**From:** [REDACTED]  
**To:** [Hinckley SRFI](#)  
**Subject:** Hinckley National Rail Freight Interchange response by IP 20040233  
**Date:** 07 February 2025 10:04:58

[REDACTED]  
RE: HNRFI - TR050007

Comments on the additional information supplied by the Applicant, Tritax Symmetry Hinckley, in response to the Secretary of State's "Minded to Refuse" letter of 10th September 2024 by Diana Harrold and David Harrold. IP number 20040233.

**SAPCOTE ENHANCED
SCHEME
VISIBILITY TO
PEDESTRIAN CROSSINGS**

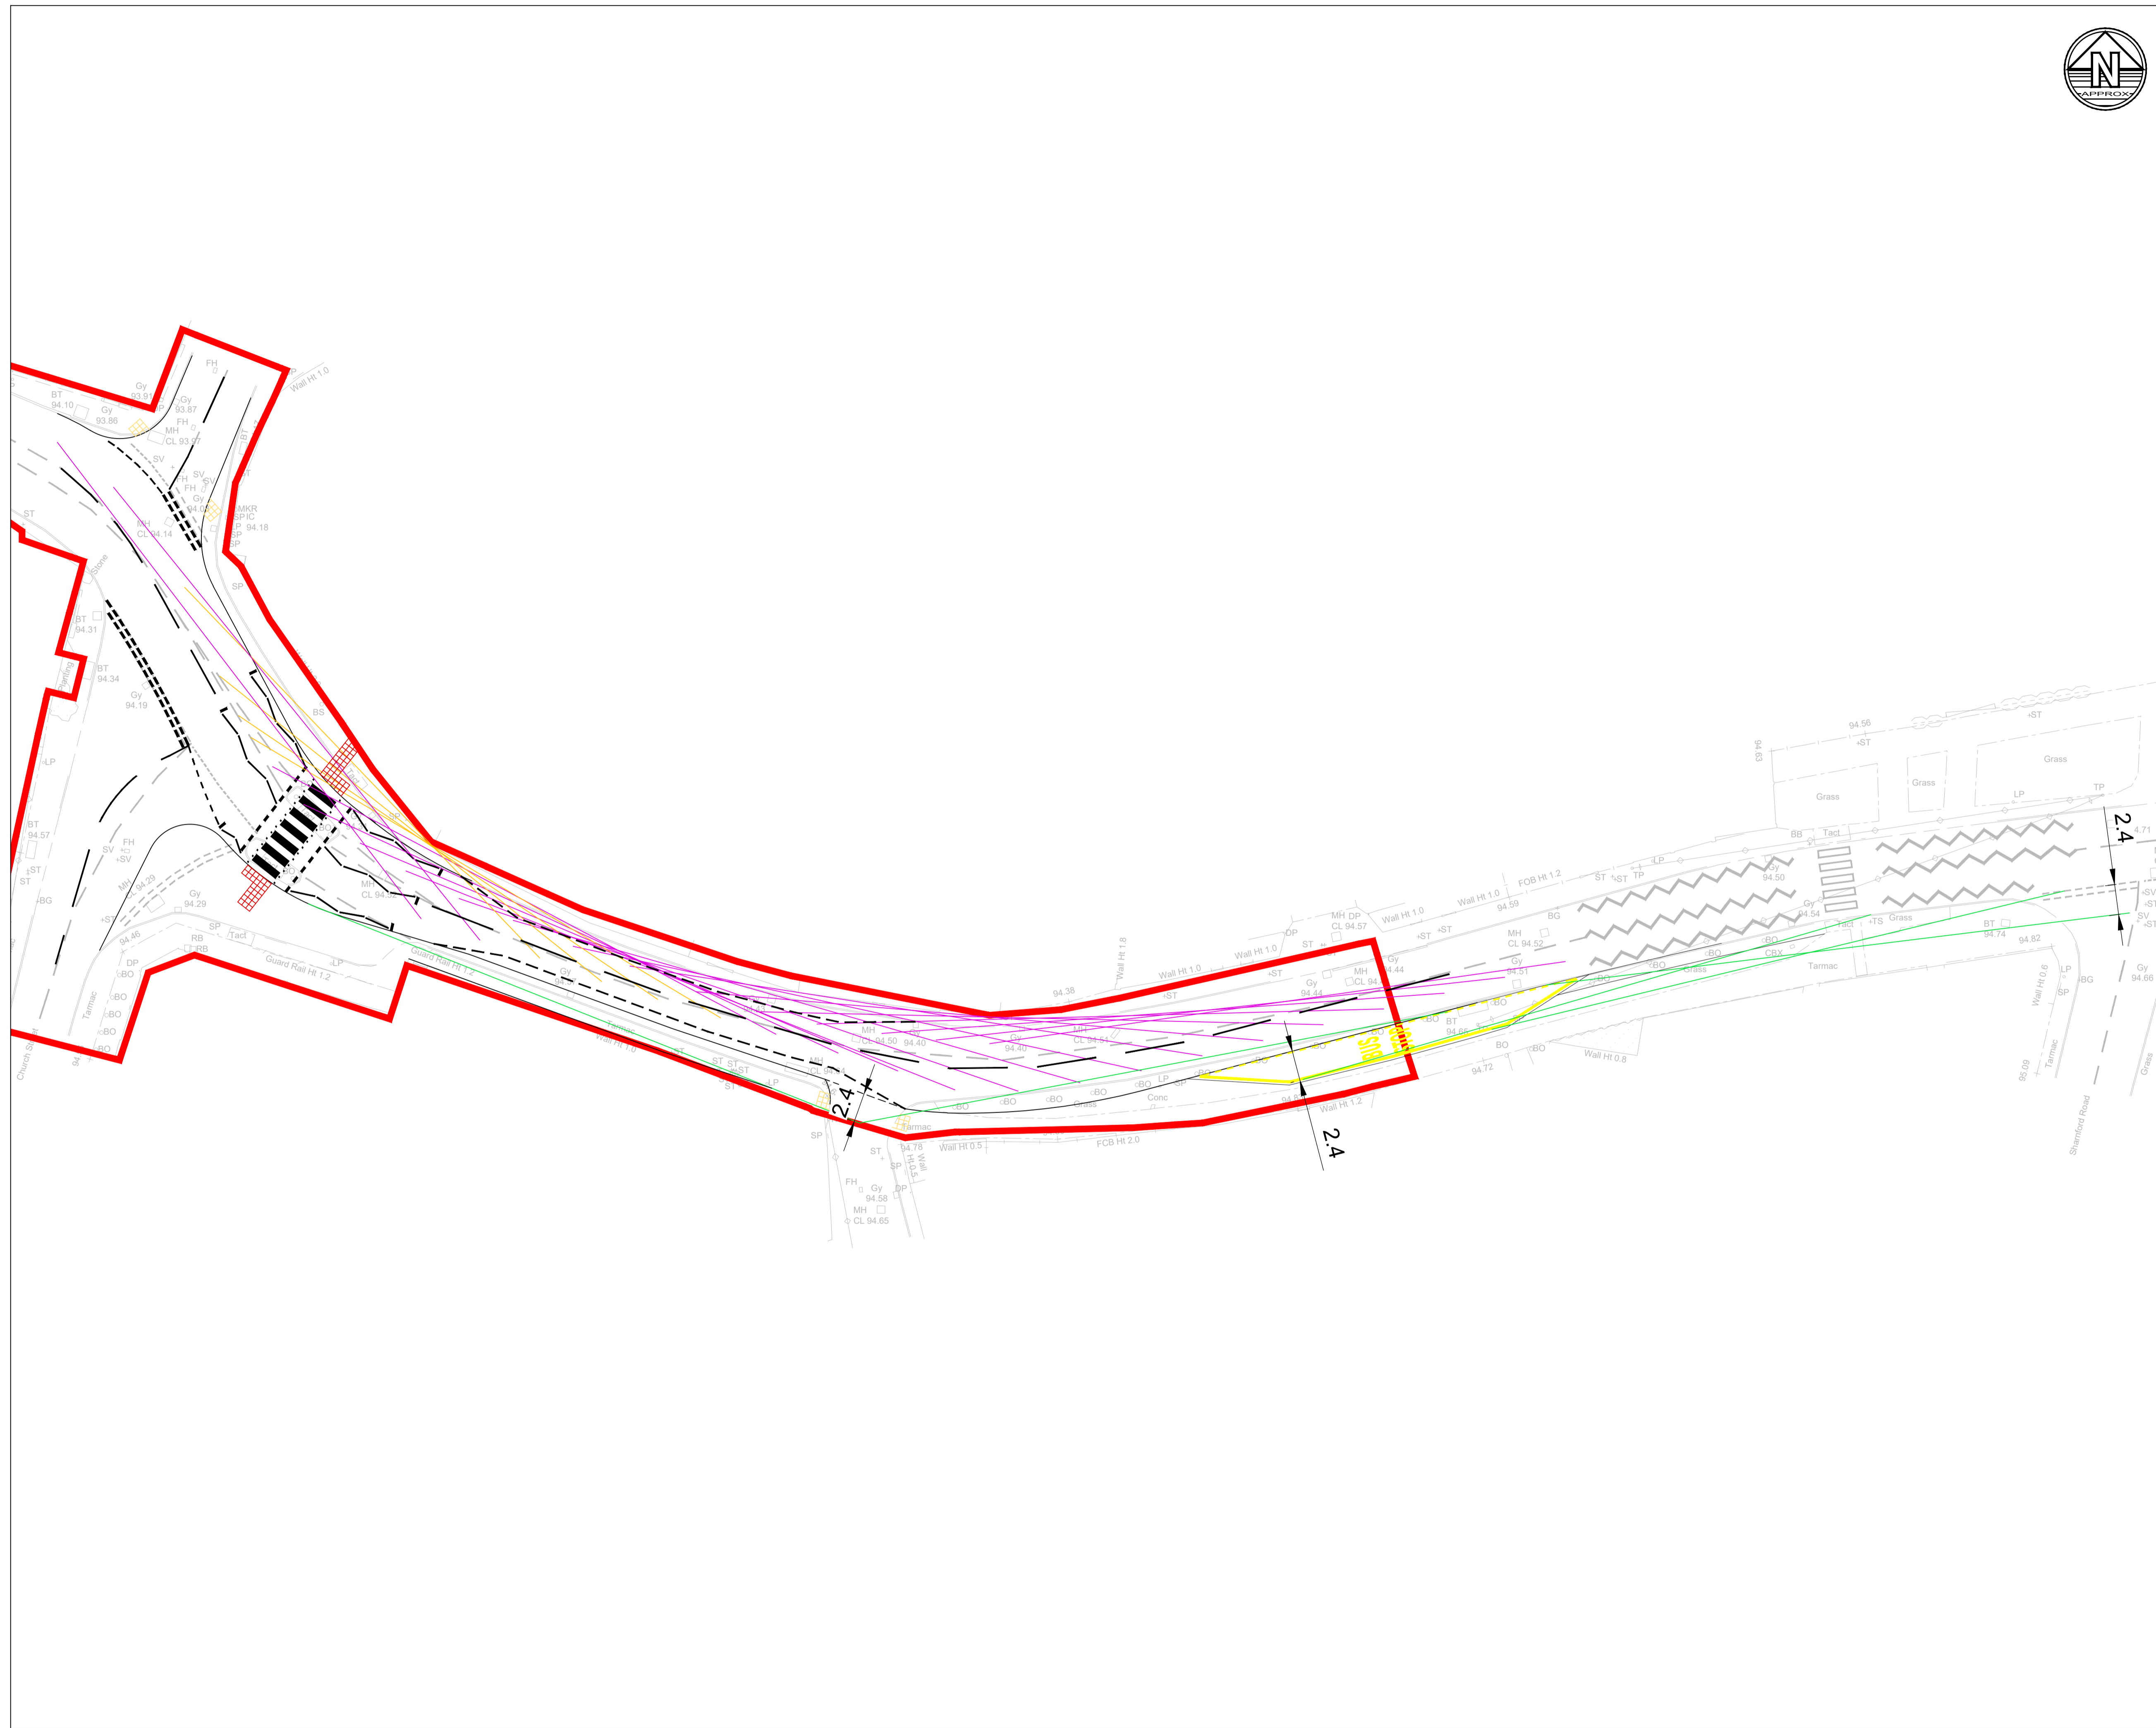
With respect to visibility at the proposed zebra crossing. The applicant claims that the required visibility can be achieved with an 0.8m set back distance on one side, 1.2m on the other. It has to be mentioned that a) many parents with pushchairs would be using this crossing, therefore may require more than 0.8m, b) there is a care home only a little way down Church Street (first building past the co-op) which generates additional light traffic, c) There is a parcel pick up point outside the co-op in Church Street, d) There is a cash machine on the corner at the Co-op. All of these things can cause visual distractions including blockages to the line of sight. Therefore we do not believe this "just enough" approach is satisfactory, and that this is, in fact, a very unsafe place to allow more HGV traffic even with the proposed changes.
